DEPARTMENT OF PLANNING & INFRASTRUCTURE

SUBJECT: MODIFICATION TO THE WOLLONGONG HOSPITAL REDEVELOPMENT (MP 10_0213 MOD 2)

To determine a modification request (MP 10_0213 MOD 2) for the Wollongong Hospital Redevelopment. The modifications comprise changes to the façade, clarification on the height of the approved building, reduction in the number of bicycle spaces and the addition of a roof top plant room.

DRAWING TITLE:
LEVEL 6 - PLANT ROOM PLAN

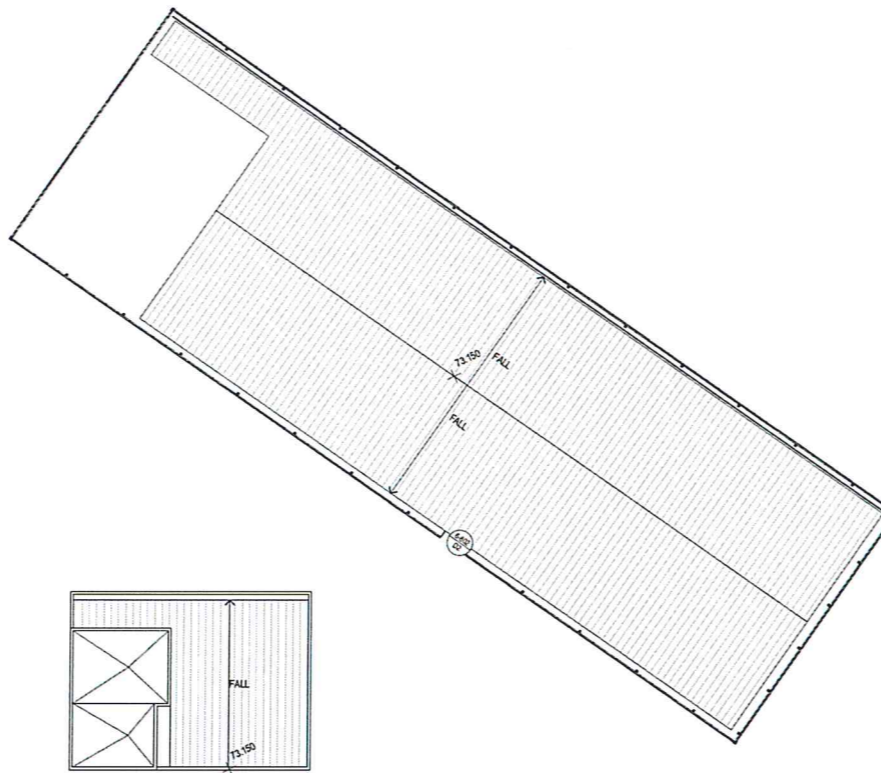
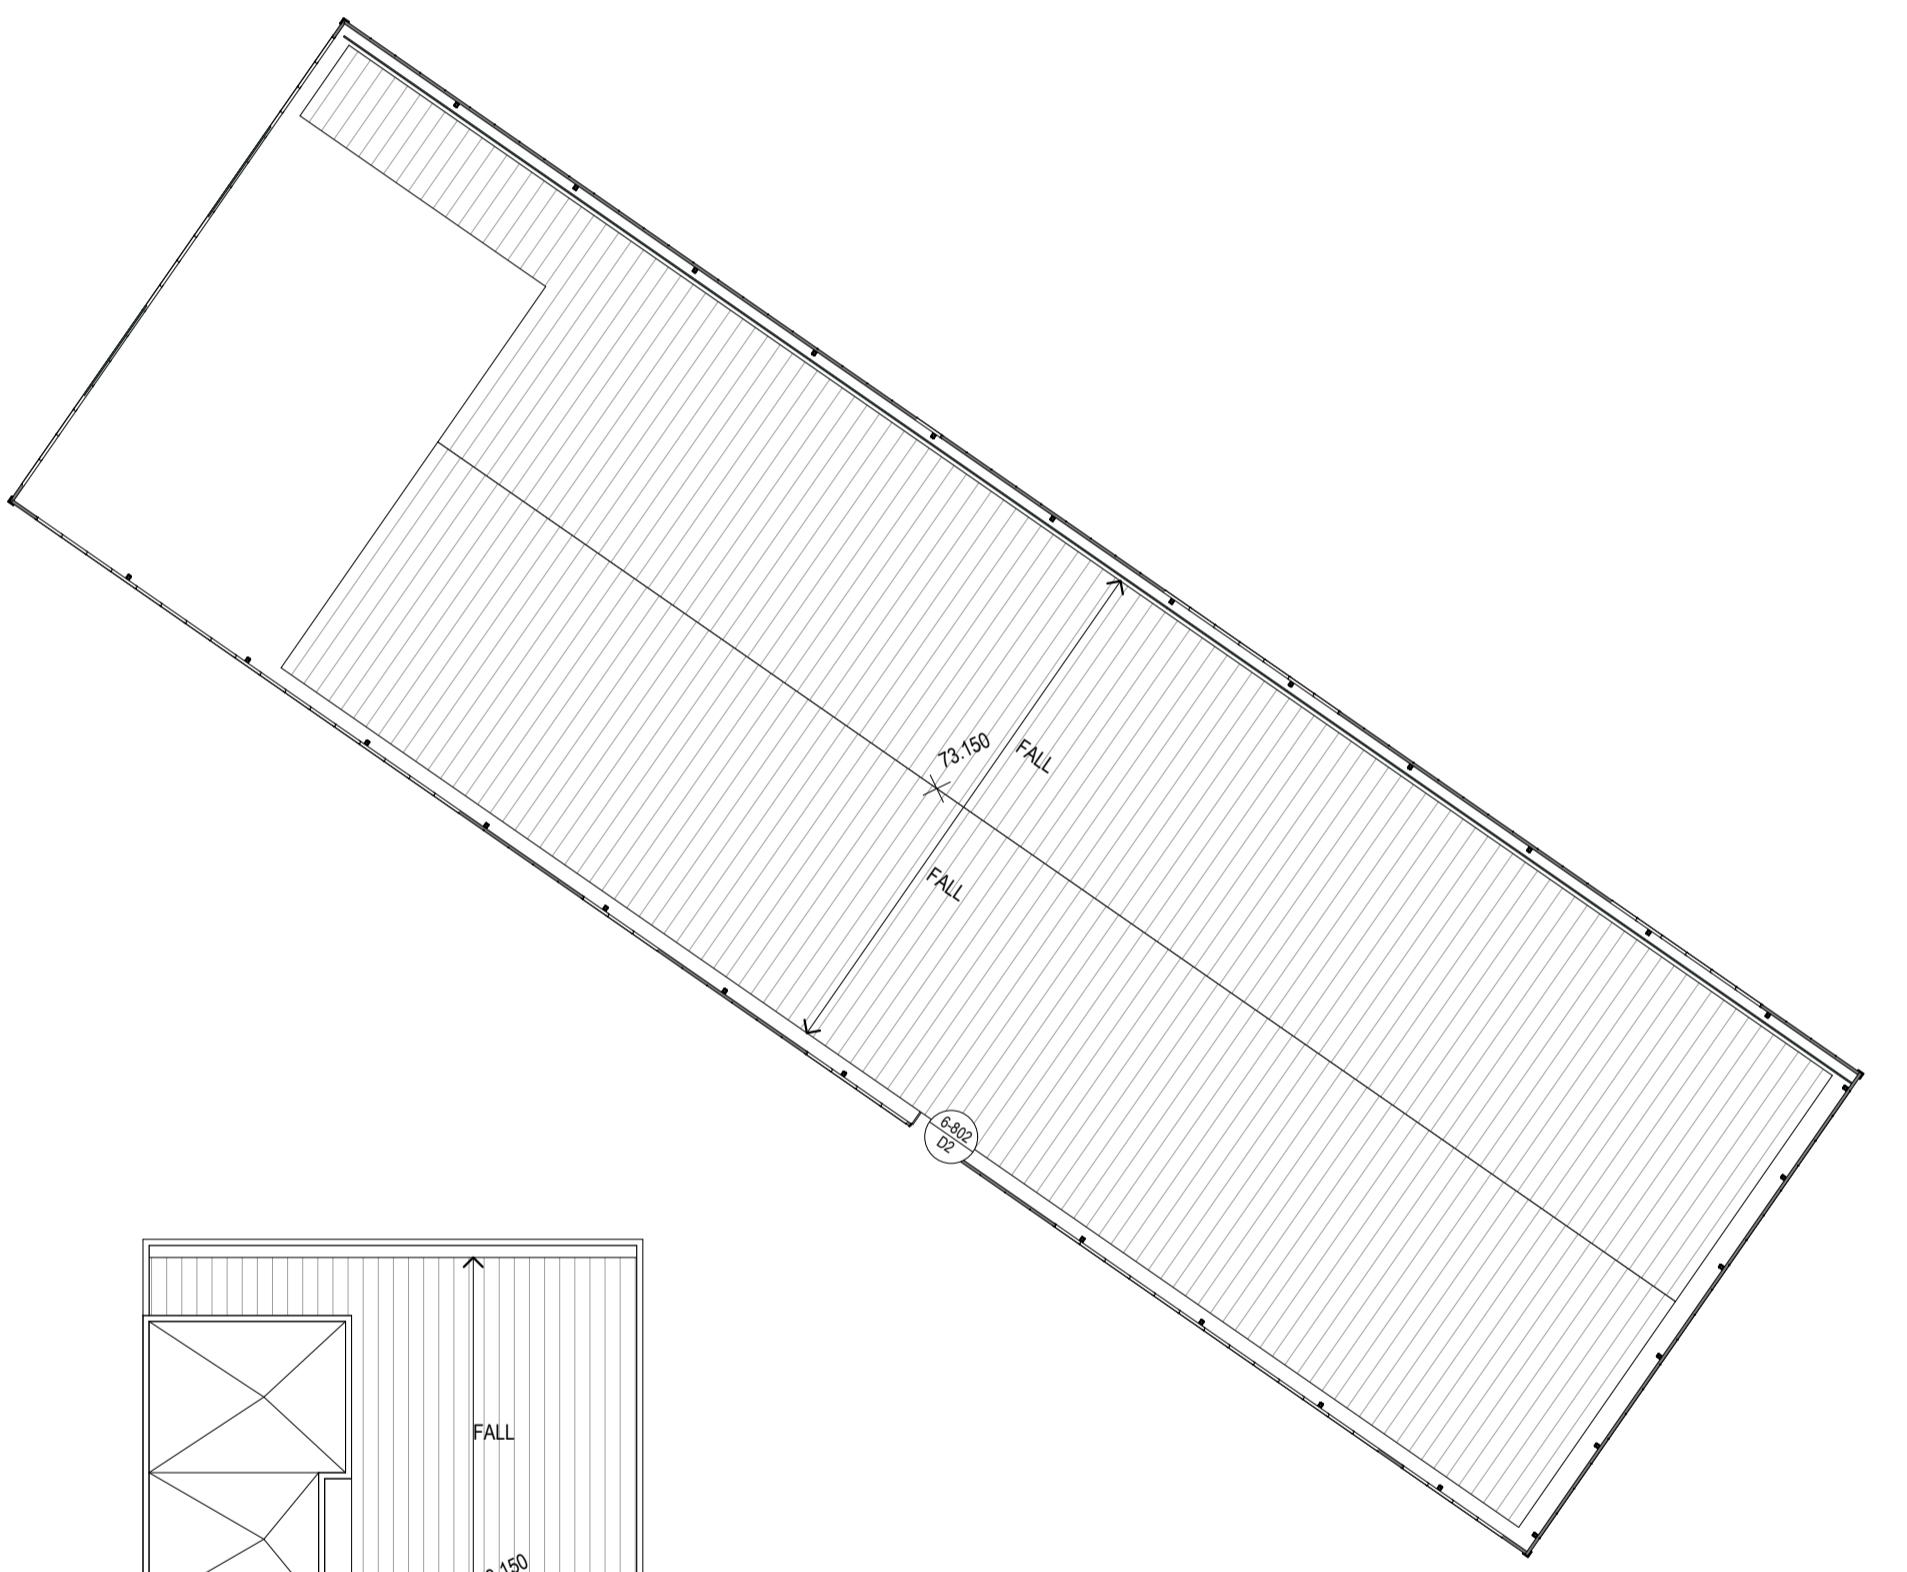
The department considers the proposal for an additional plant room to the southern wing to offset the reduced size of the plant room of the northern wing (see **Figures 4** and **5**) acceptable given it is located internally and is not visible from the public domain. The proposed changes would not have any view impacts and the height would be the same as the height of the plant room of the northern wing.

DRAWING TITLE:
ELEVATION SHEET 2

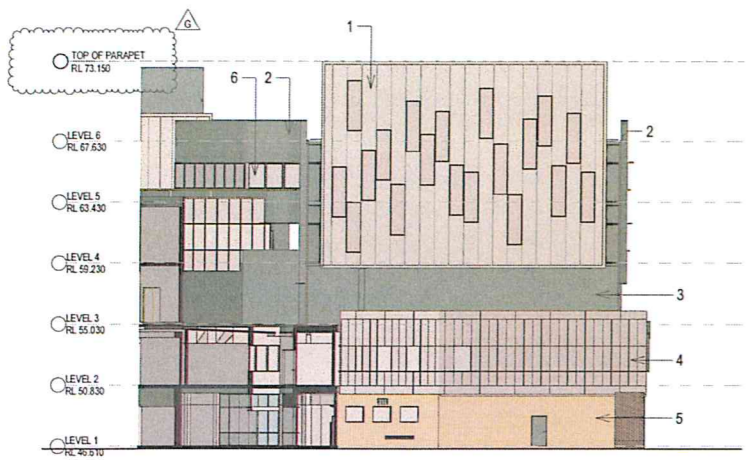
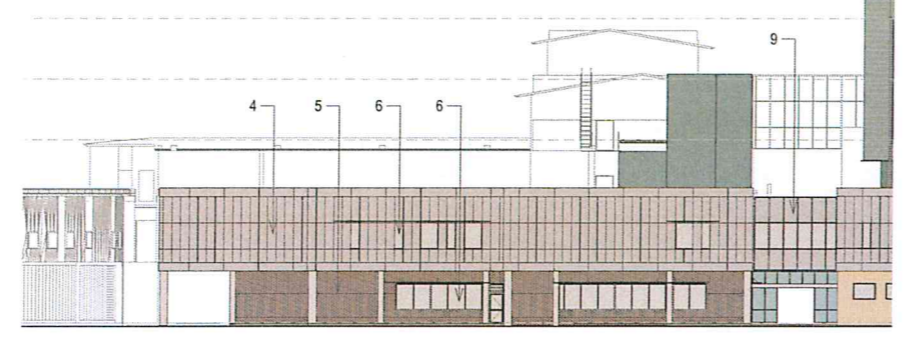
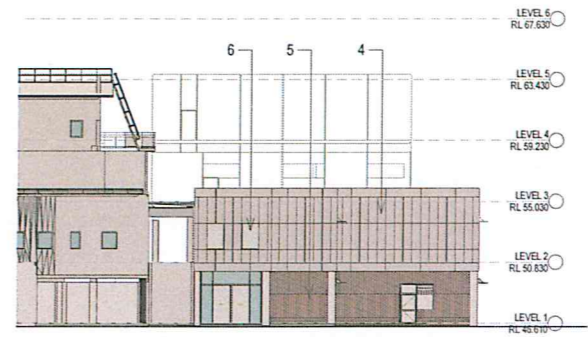
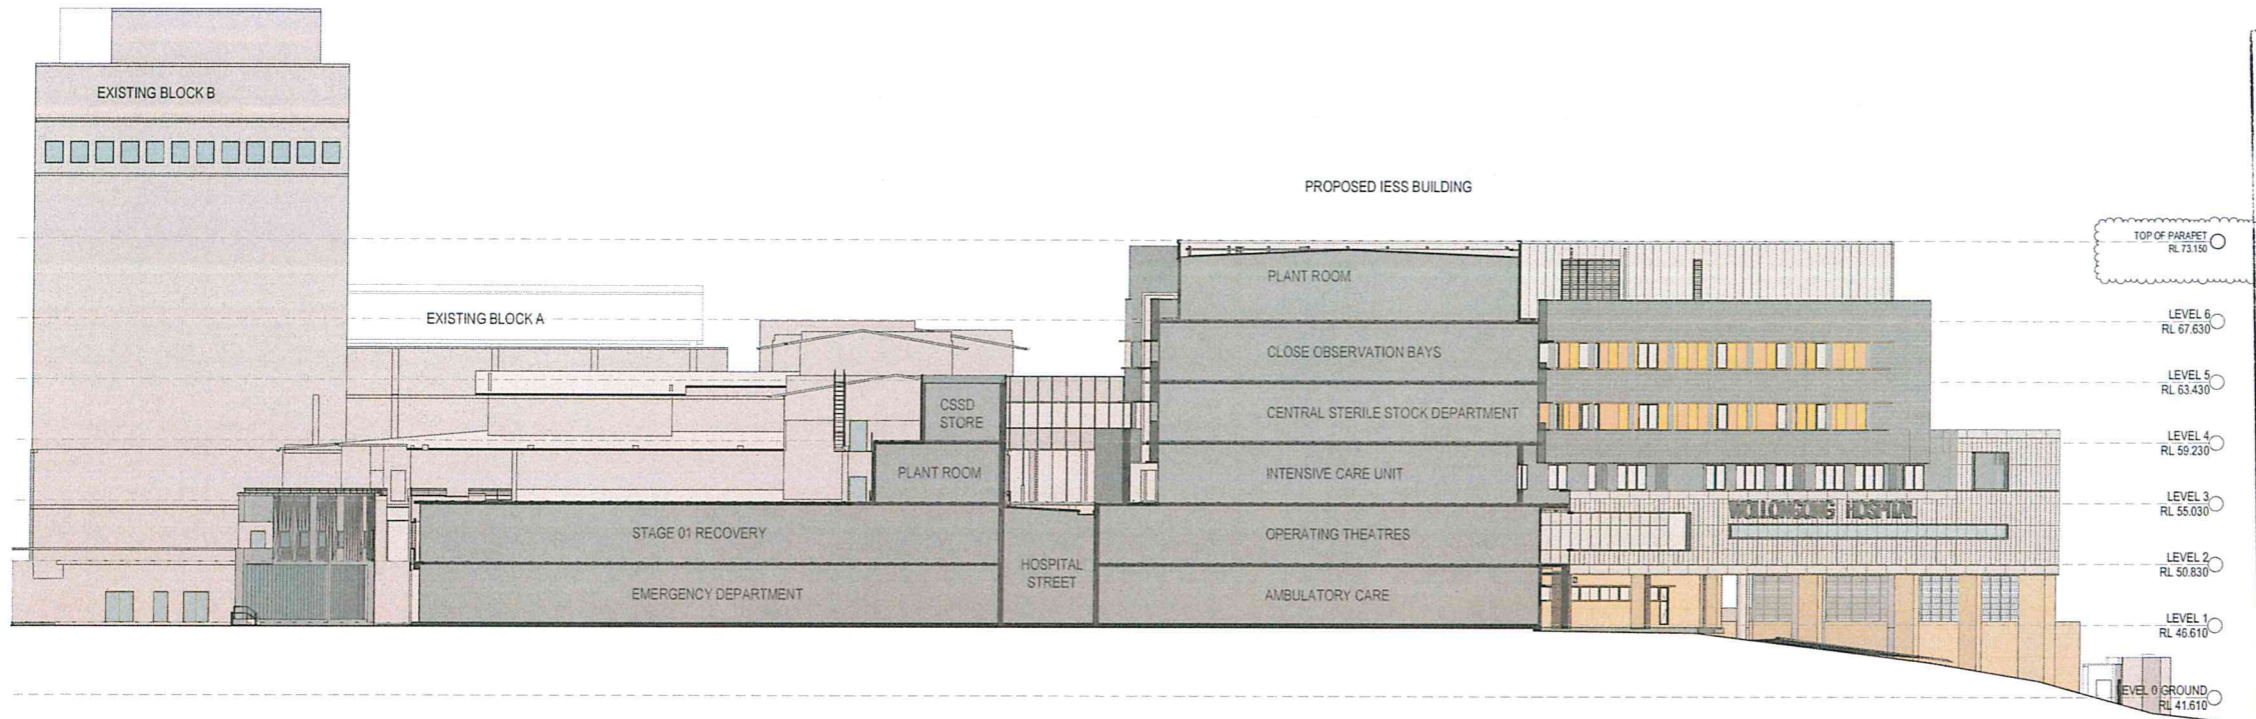
The eastern elevation of the building has also been simplified by removing the glazing and vertical articulation, resulting in a solid form (see **Figure 2**). The department accepts that due to the functions located behind this elevation (predominantly fire stairs and plant) it would be unreasonable to require costly glazing treatments and the like to be provided. The department considers the projecting panels that have been incorporated in the design

of the eastern elevation provide visual interest which reduces the visual intrusiveness of the eastern facade.

<table><tr> <td>E</td><td>YS 05.12.13</td><td>ISSUED FOR APPROVAL</td></tr><tr> <td colspan="3">DRAWING TITLE: <b>ELEVATION SHEET 1</b></td></tr></table>

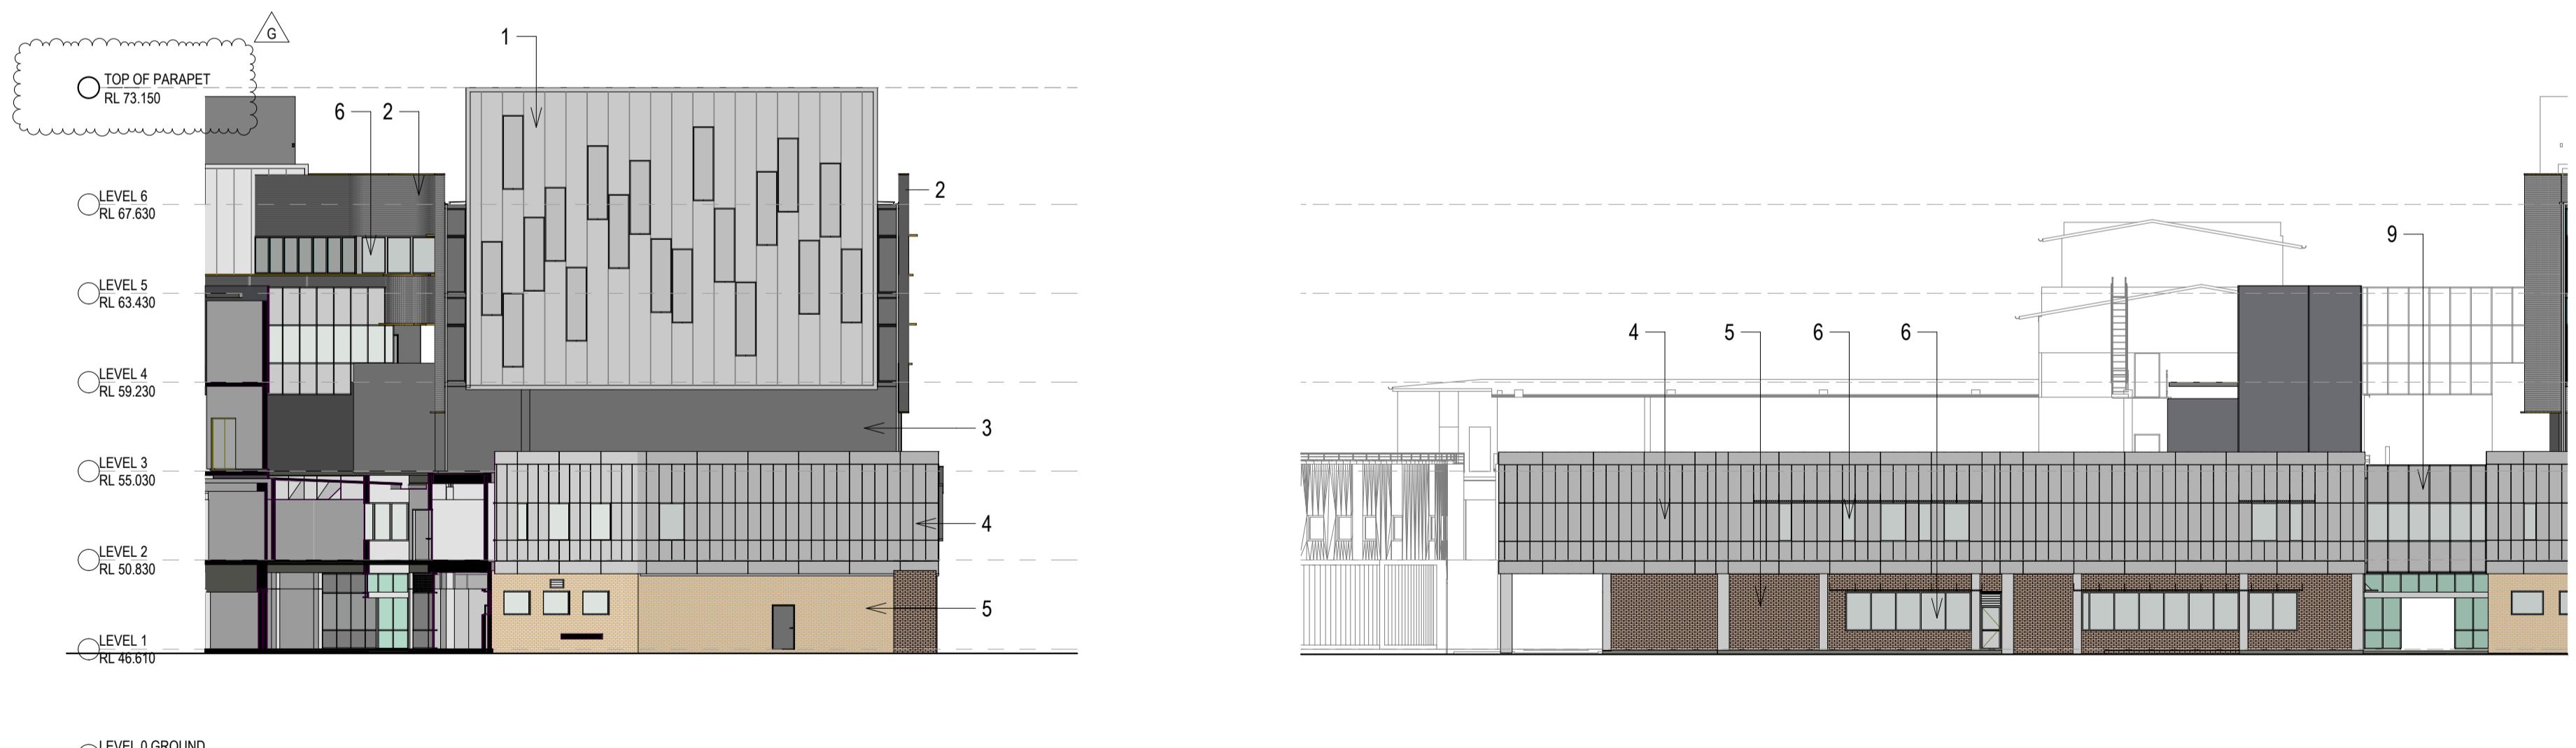
The proposed façade changes have the potential to result in a more visually intrusive built form by accentuating the visual mass of the building given the more minimalistic approach to the modulation and articulation of the façade (see **Figures 1 and 2**). The revised design removes vertical elements, including a reduction in the openings, blade walls, material changes, such as glazing and louvres, which provided visual interest along the lengthy Loftus Street facade. The proponent has simplified the design to reduce ongoing maintenance costs associated with cleaning of the facades and to reduce construction costs.

The department considers the revised design of the lower levels of the building, with an increase in the use of brick, provides a more sympathetic response to the adjacent heritage item and therefore can be supported. The revised design of the Loftus Street elevation maintains a visual separation between the podium and upper levels by setting back the upper levels and providing distinctive colour palettes for the two modulated elements (see **Figure 2**). A further setback of the plant level is also provided to minimise the bulk along the Loftus Street elevation. The department considers the revised design acceptable as the visual separation and projecting corrugated metal façade with orange fibre cement panels and projecting awnings provide visual interest along the extensive façade. The additional setback of the plant level also reduces the massing of the building.
